TfNSW Reference: SYD26-00279/01
DPHI Reference: SSD-100006957

**EXHIBITION OF ENVIRONMENTAL IMPACT STATEMENT
BUILD-TO-RENT
607 PACIFIC HIGHWAY, CHATSWOOD (CHATSWOOD DIVE SITE)**

TfNSW has reviewed the EIS and provides suggested Development Consent conditions for the Department of Planning, Housing, and Infrastructure's (**DPHI**) consideration in **TAB A**.

Figure 46: BTR Podium Ground Floor Plan

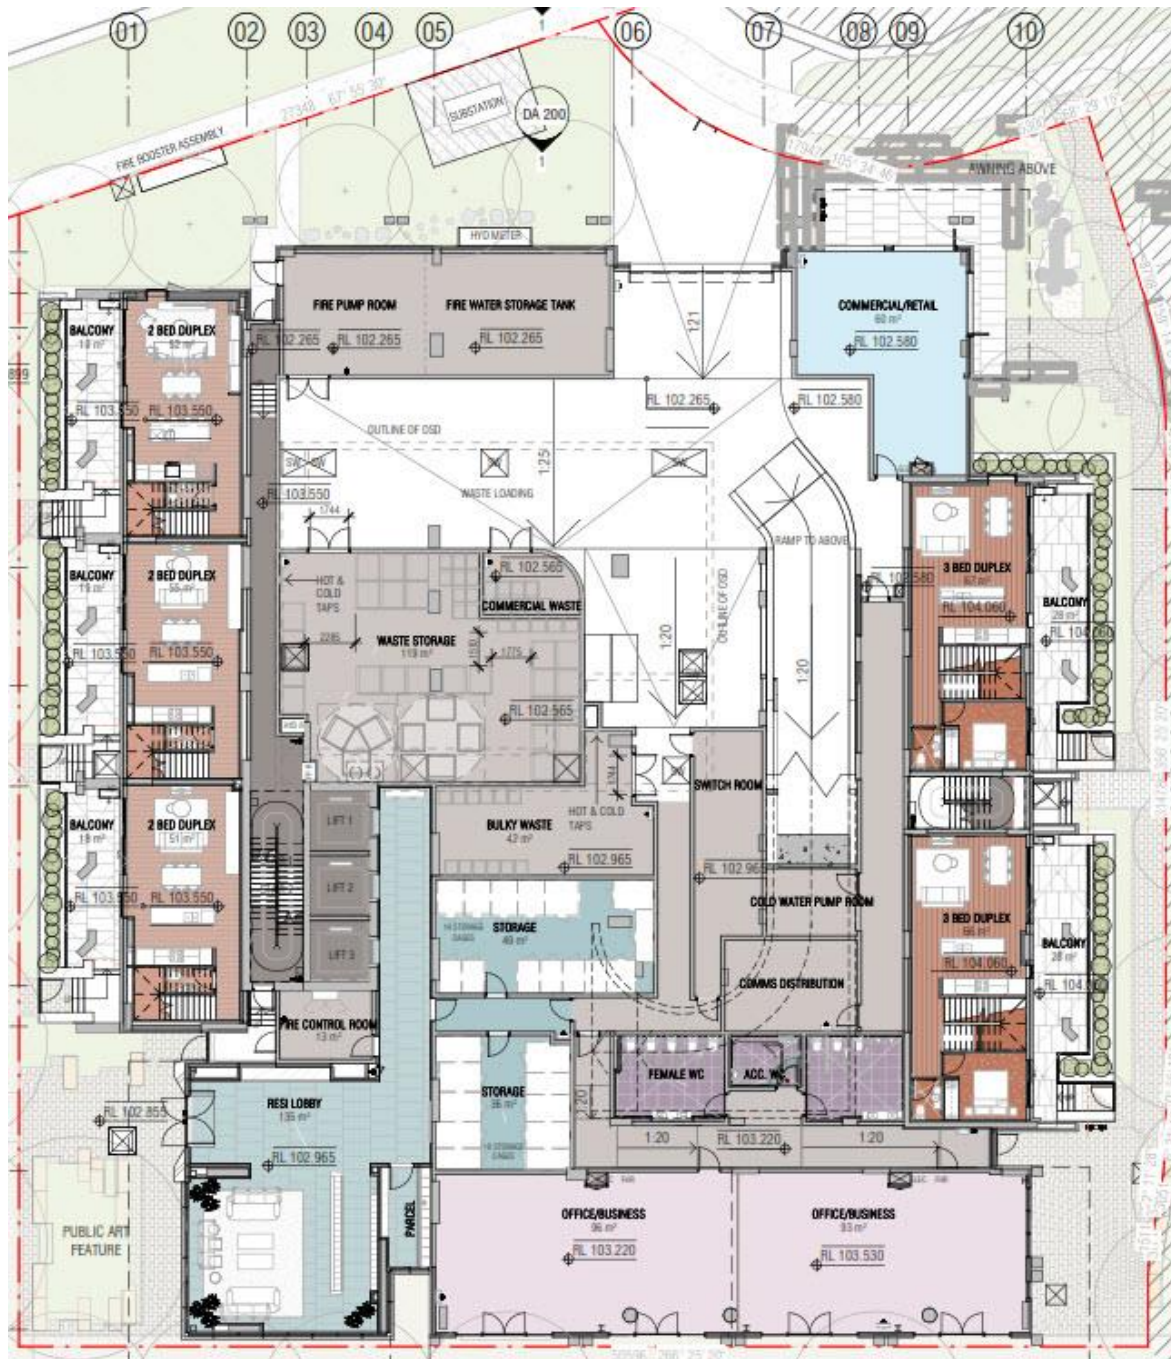
- It is noted that vehicular access to the development is proposed via the cul-de-sac at the end of Nelson Street, where sight distance for drivers is limited. Appropriate mitigation measures need to be provided to ensure safety at the proposed access point, or the access should be relocated to a location that provides adequate sight distance along Nelson Street.
